GATWICK AIRPORT NORTHERN RUNWAY PROJECT

PLANNING INSPECTORATE'S REFERENCE: TR020005

ISSUE SPECIFIC HEARING 8

POST-HEARING SUBMISSION ON AGENDA ITEM 6: NOISE

Diagram 2.1 Current Gatwick Noise Insulation Scheme

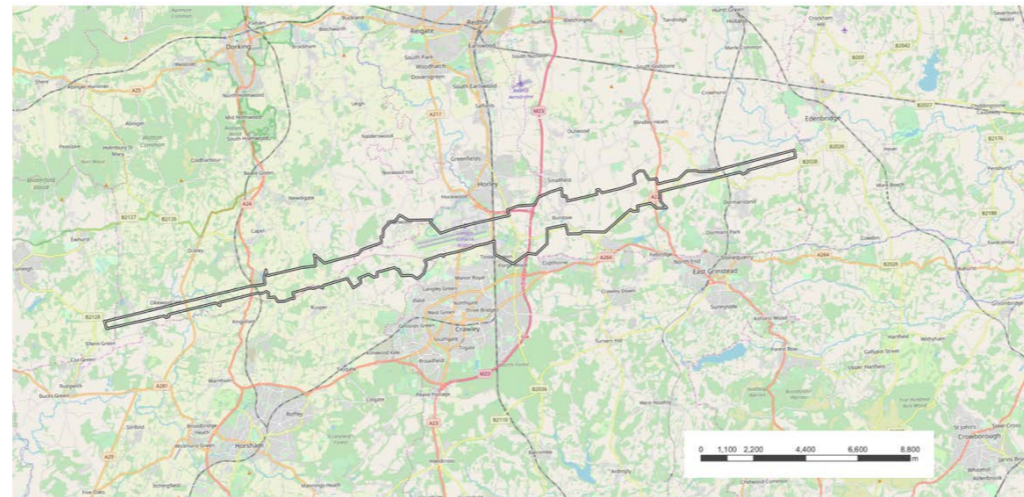
<p>6.2</p>	<p>The ExA will ask the Applicant and other IPs about the use of the proposed noise insulation scheme as a form of receptor-based mitigation. This would include reference to the Environmental Statement Appendix 14.9.10: Noise Insulation Scheme [REP4-017] and include:</p> <ul style="list-style-type: none"> • How the mitigation is secured, initiated, designed, implemented and maintained; 	<p><u>Topic Working Group Proposals</u></p> <p>The Authorities cautiously welcome the proposed topic working group and would be happy to engage in principle. However, they highlight concerns that previous working group meetings have not resulted in any of the concerns raised by stakeholders being meaningfully addressed. Therefore, the Authorities also consider that the ExA would benefit from a written response from the Applicant to the points raised in the Authorities’ submission, REP5-094, at Section 3.</p> <p>The Authorities will not go through the full, detailed list of their concerns here, as they are comprehensively set out in that section. However, the Authorities will highlight a few key points:</p>

<ul style="list-style-type: none"> • Efficacy of the mitigation in terms of the avoidance of likely significant effects; and • Extension to non-residential receptors. 	<ul style="list-style-type: none"> • The Authorities believe there that there is merit in using single-mode contours to determine the extent of the qualifying contours. • The Authorities suggest determining the extent of qualification of the insulation scheme based on pragmatic community boundaries rather than somewhat abstract polygons on a map. This will avoid situations where parts of a community might not qualify despite experiencing very similar effects. • It is imperative to protect health that the noise insulation scheme includes the area within the one additional awakening contour as the inner zone. • The inner zone must commence at 60dB LAeq 16hr (day) and not 63 dB. This approach aligns with the recommendations in Aviation 2050 (paragraph 3.122), where the government is signalling that 60dB merits noise insulation schemes. • The night metrics need to taper beyond the inner zone to mitigate the total adverse effects <p>The reliance on the day outer zone to provide mitigation for night time effects appears to have been suggested at ISH8 and this is inappropriate as the mitigation for such effects is different. Therefore, the insulation offer needs to be improved for the night.</p> <p>These are the Authorities' primary concerns at a high level, and they hope to see some movement on these points in the current scheme.</p> <p>There was a discussion regarding what appears to be a satisfaction survey with the existing scheme. We look forward to receiving a copy of this at D6. The Authorities wish to emphasise to the ExA of the need for the Applicant to undertake detailed assessment of the appropriateness and long-term effectiveness of the future scheme on an ongoing basis. The information derived is to provide detailed feedback and result in adjustment of the scheme to continually improve it.</p>
